CITY OF ALBUQUERQUE

June 6, 2022

Re: **Murphy (Oil) Express**
10601 Unser Blvd NW
Traffic Circulation Layout
Engineer's Stamp 05-28-2022 (A11-D017A)

SHEET NO.
TCL-2

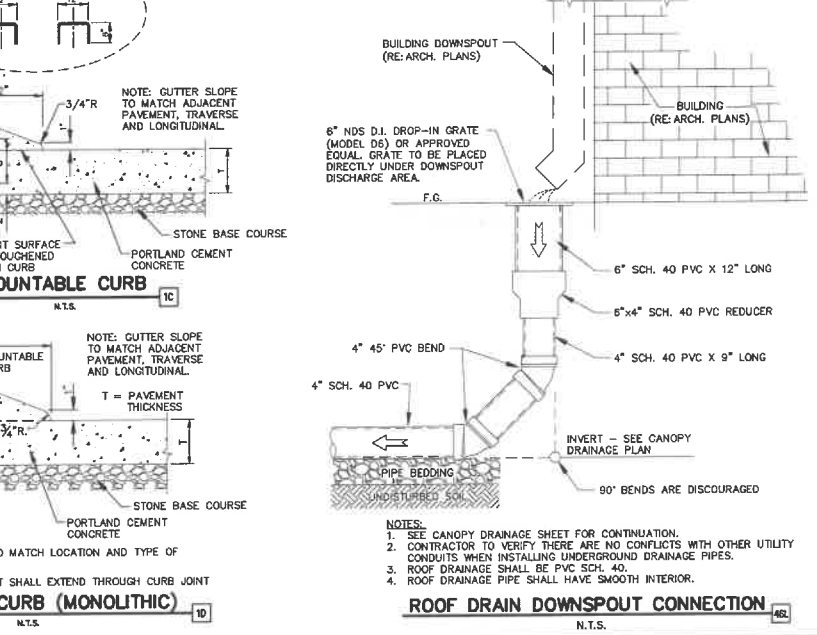
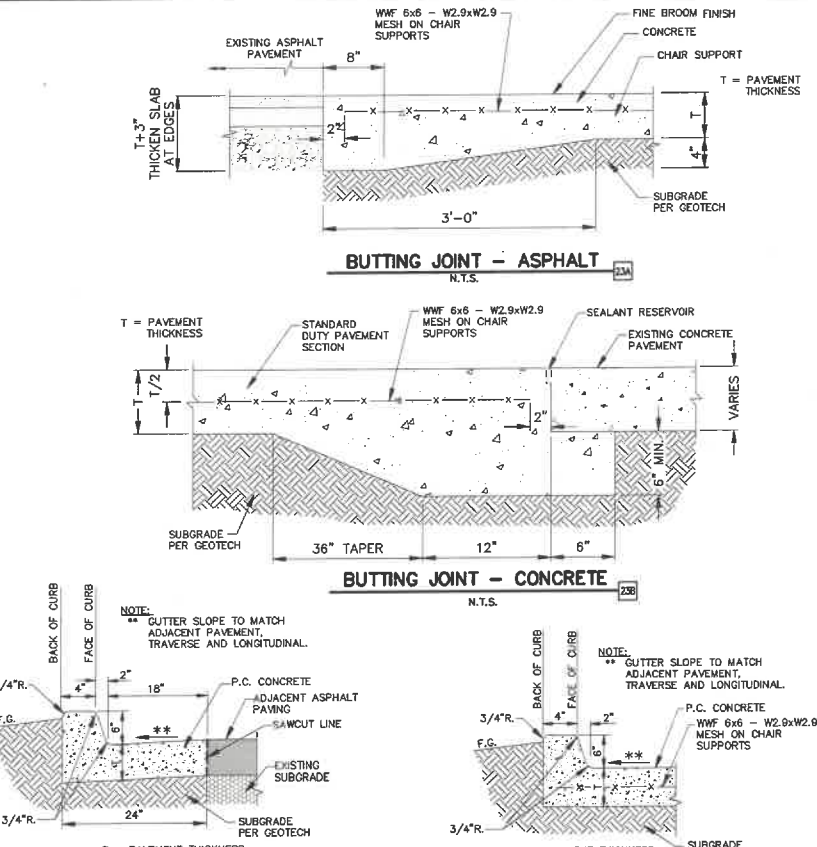
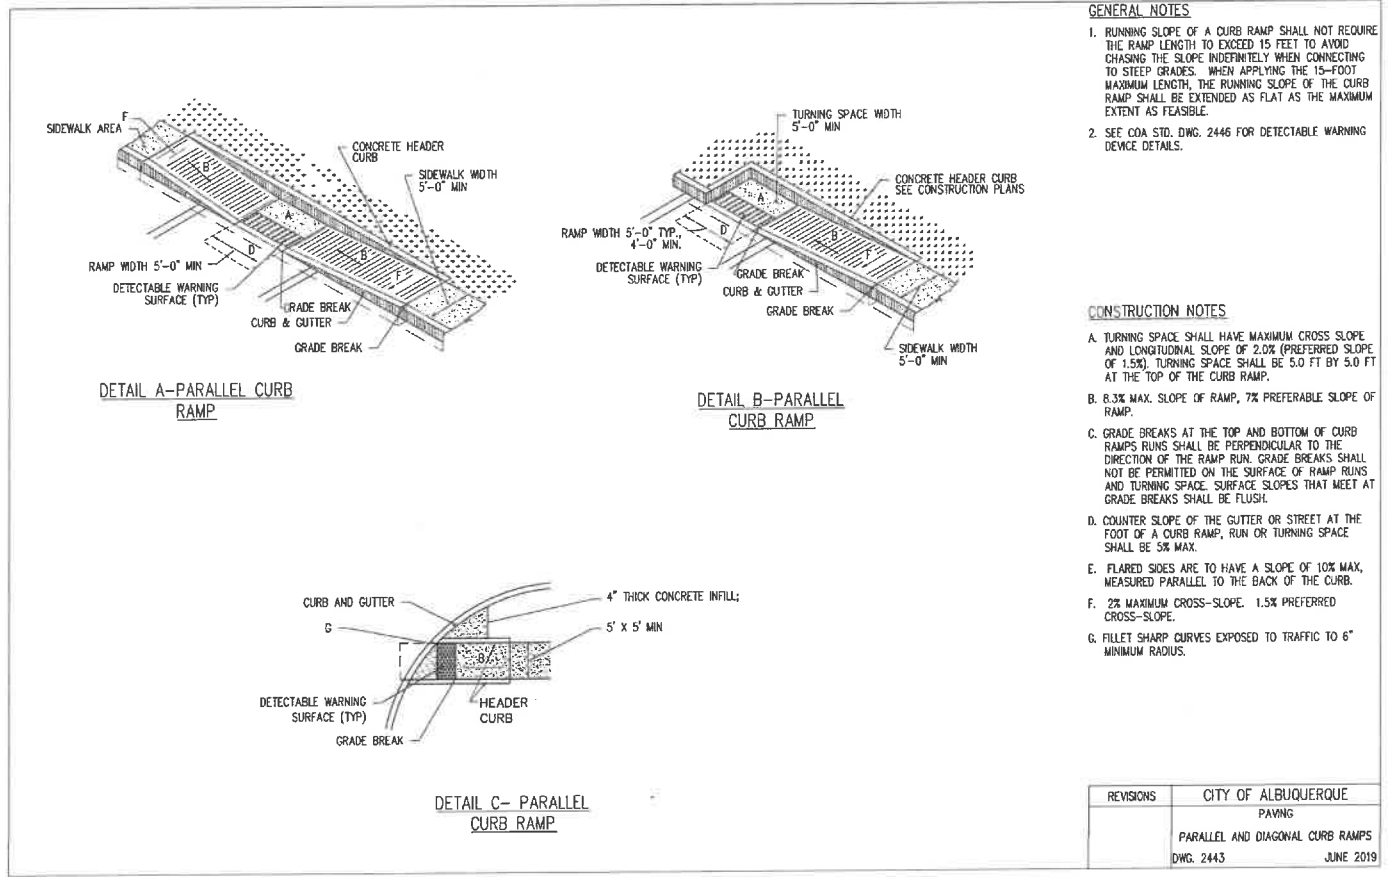
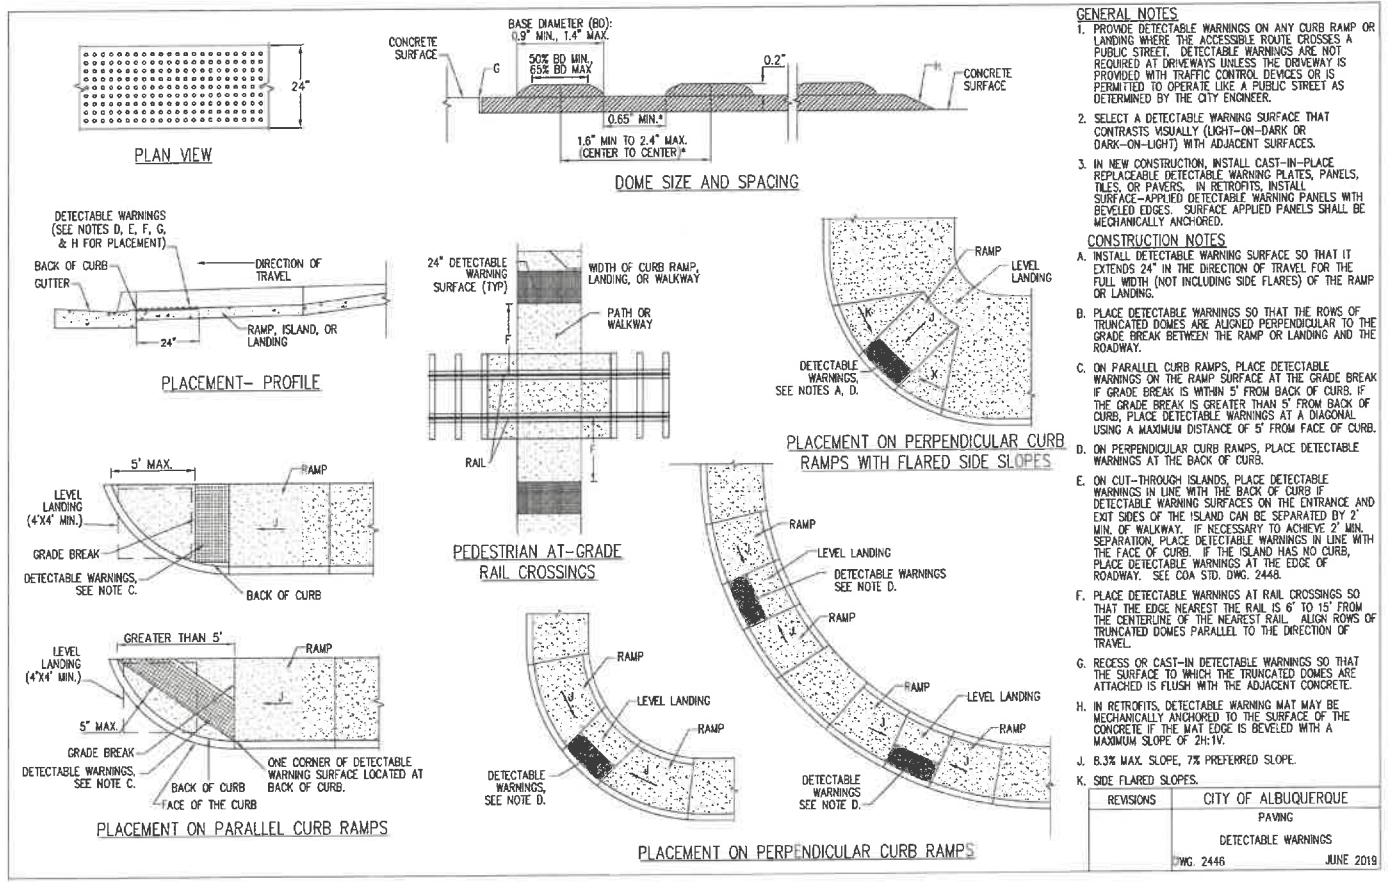
- Project A11-D017 main drive aisle coming off Bandelier and Unser be completed/approved.
- **Bandelier- Murphy Oil Site:** Private Access Easement drive aisle be constructed/completed/approved.
- **Work Order (SB Unser):** 30 ft Wide Access Driveway plus ADA ramps (WO-683083) and right turn lane (WO: 683084) be completed/approved.

2. The main Access Easement drive aisle off Bandelier be completed/approved o

3. The proposed 1st entrance drive onto site:

- It is too close to Unser frontage/turn lane and its Main entrance throat length will need to comply with DPM 7.4 (K)(15) throat length.
- The main entrance off Unser is the primary access to all present and future development design and as such will require a throat depth of 100 ft off the right turn lane.
- This entrance is not shown on RBA Architecture design for constructing the Western drive aisle.
- Proposed ramp for this entrance will need details. **Provide reference notes to the location of the ramp detail because 3M just specifies Detectable warning surface and not ramp detail.**
- Entrance width is too wide. Please adjust for two way traffic and delivery vehicle. **Provide turning templates.**

4. Barricades will be required at the end of the 26.43 drive aisle.

5. A Intersection Sight Distance off the Unser entrance will need to be provided (Not shown).

6. Shared Site access: driveways that straddle property lines, or are entirely on one property but are to be used by another property, shall have an access easement. Please include a copy of your shared access agreement with the adjacent property owner. The Cross Access Easement will be between Lot 5 (Murphy Oil Express) and Lot 6. Provide the approved copy.
7. A copy of receipt for Resubmittal fee's paid (\$75+tax) will need to be provided for each resubmittal.
8. Please provide a letter of response for all comments given.
9. A copy of receipt for Resubmittal fee's paid (\$75+tax) will need to be provided for each resubmittal.(See below)
